PROJECT NO. 1001988	APPLICATION NO. 02DRB-01448
PROJECT NAME EAST SAN JOSE COUNTY CTR	
<del>EPC APPLICATION NO.</del> H BARKER / MARK HARVOLD	
APPLICANT / AGENT	PHONE NO. 842-6789
ZONE ATLAS PAGE L-14	
<b>ONE STOP COMMENT FORM LOG</b>

DRB Application No.: <u>02-01448</u>	Project # <u>1001988</u>
Project Name: <u>M.R.G.C.D. MAP 41</u>	EPC Application No.: <u>02EPC00839</u>
Agent: <u>H Barker Architects</u>	Phone No.: <u>842-6789</u>

DRB Comments: East San Jose Community Center

SHT. NO.
1
1 OF 6

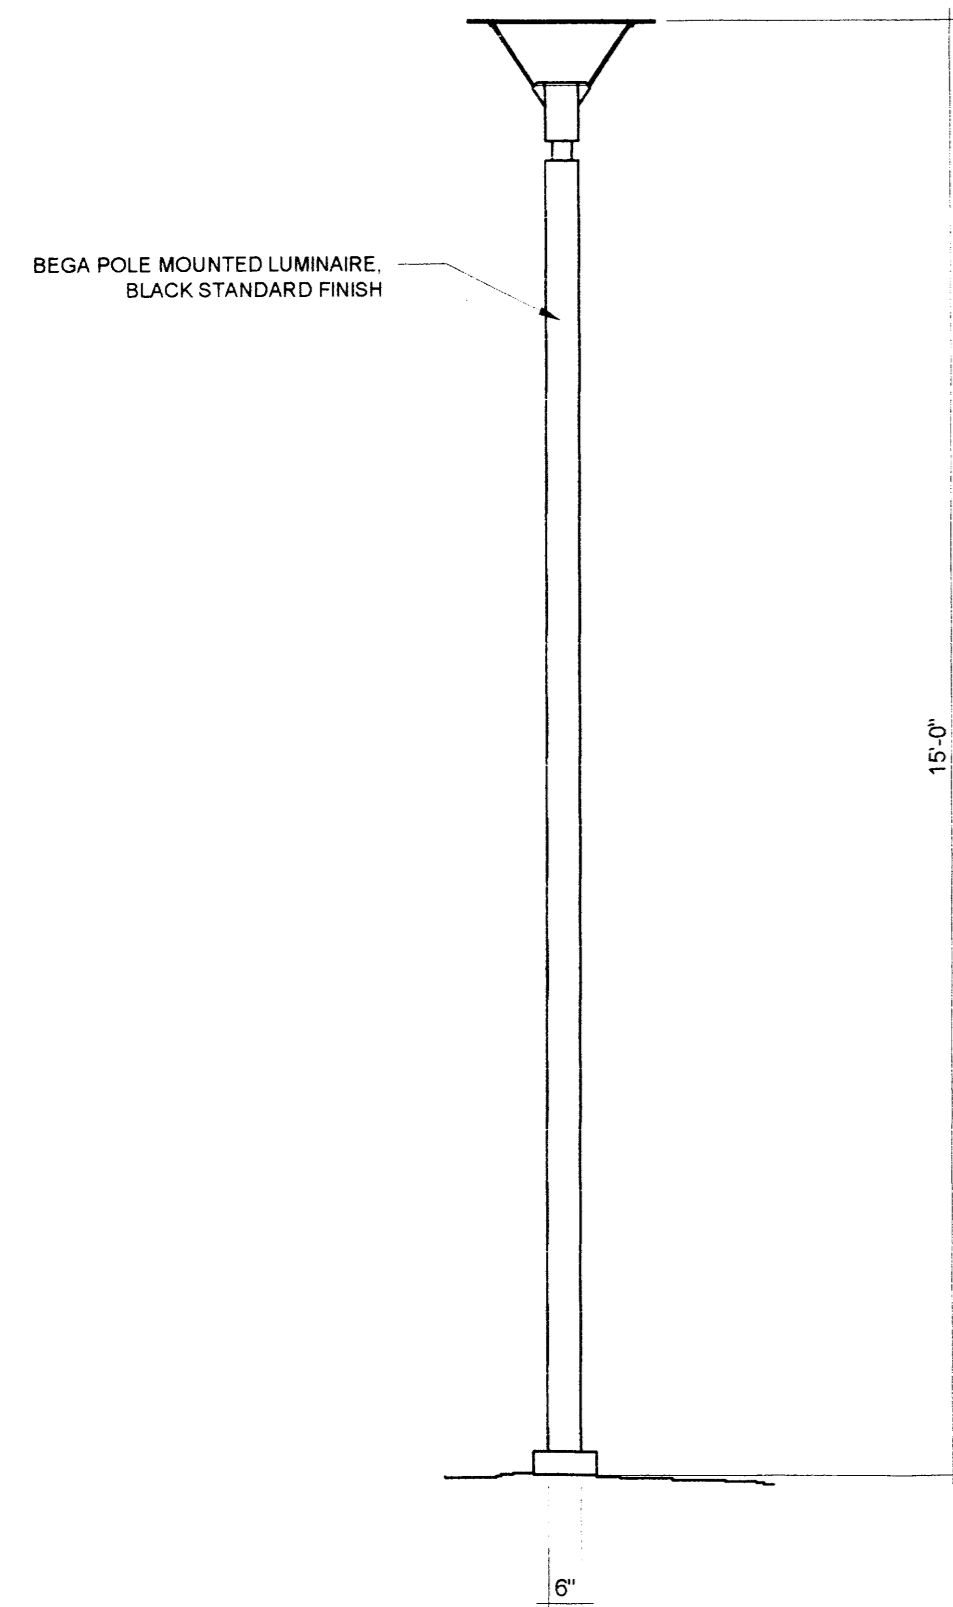
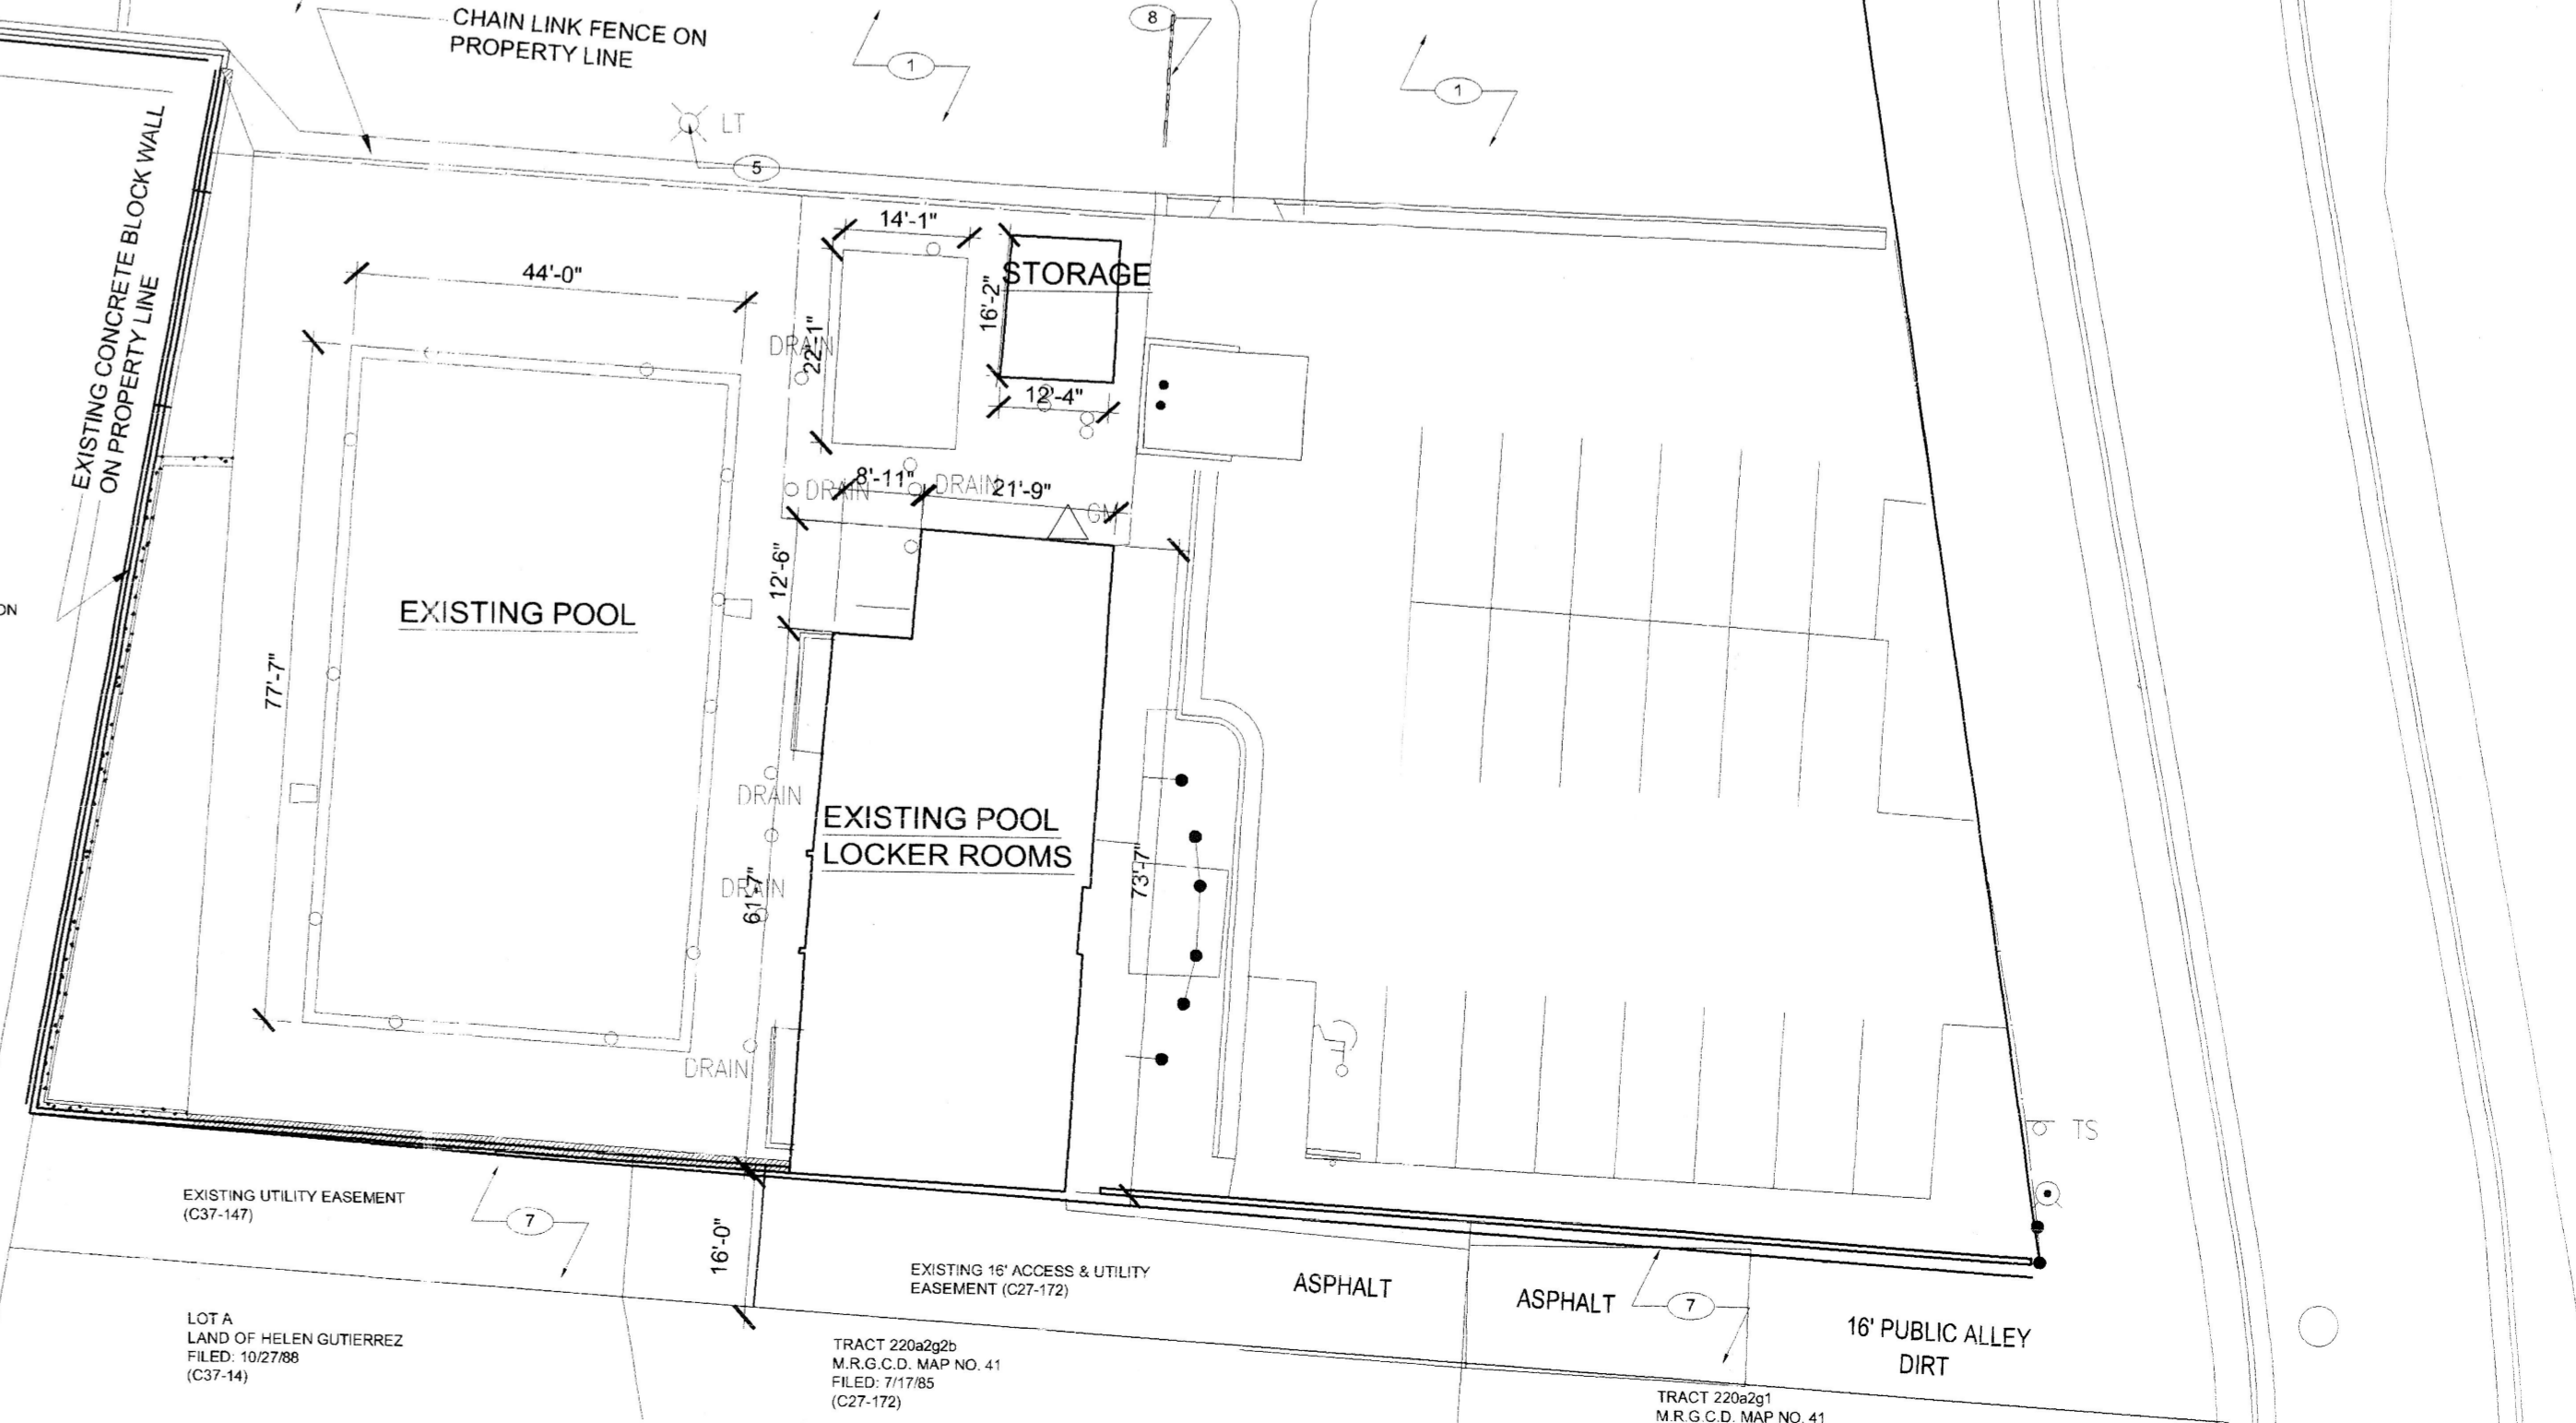
TRANSPORTATION DEV (505) 924-3990		
PLANS DISAPPROVED	DATE	DATE
PLANS APPROVED RP	DATE 10-11-02	DATE
COMMENTS:		
Please PLATE Dimensions from Sheet 5 on Sheet 1		
# Check to make sure that the plans are the same

TRANSPORTATION: More dimensions are needed.

No.	Comment
<input type="checkbox"/>	EPC condition no. 3 needs additional clarification to its response.
<input type="checkbox"/>	More dimensions are needed on the site plan.

WATER VALVE SHUT-OFF PLAN

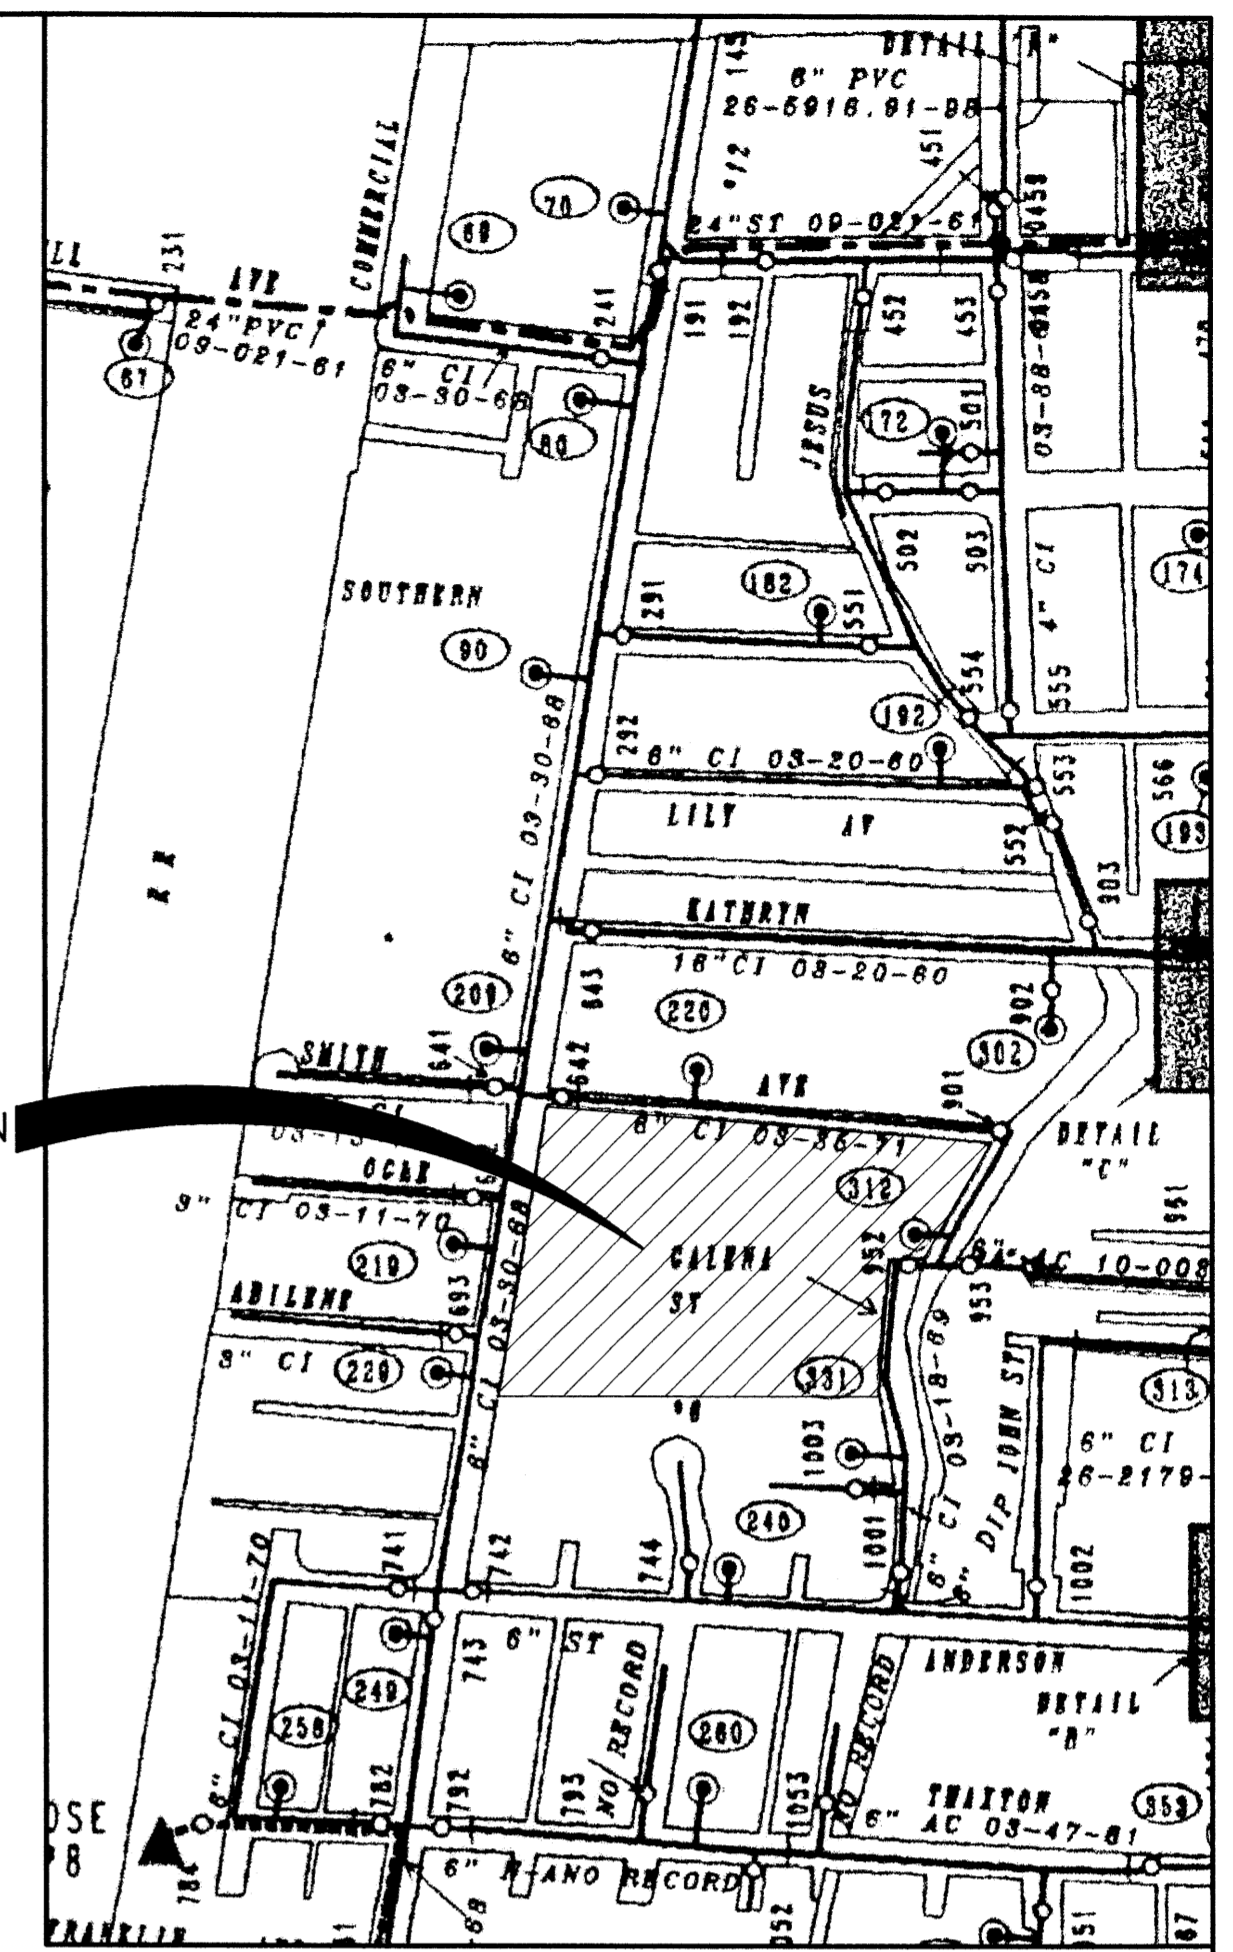
UTILITIES: revise utility plan and include as part of site plan set. show new and existing hydrants.
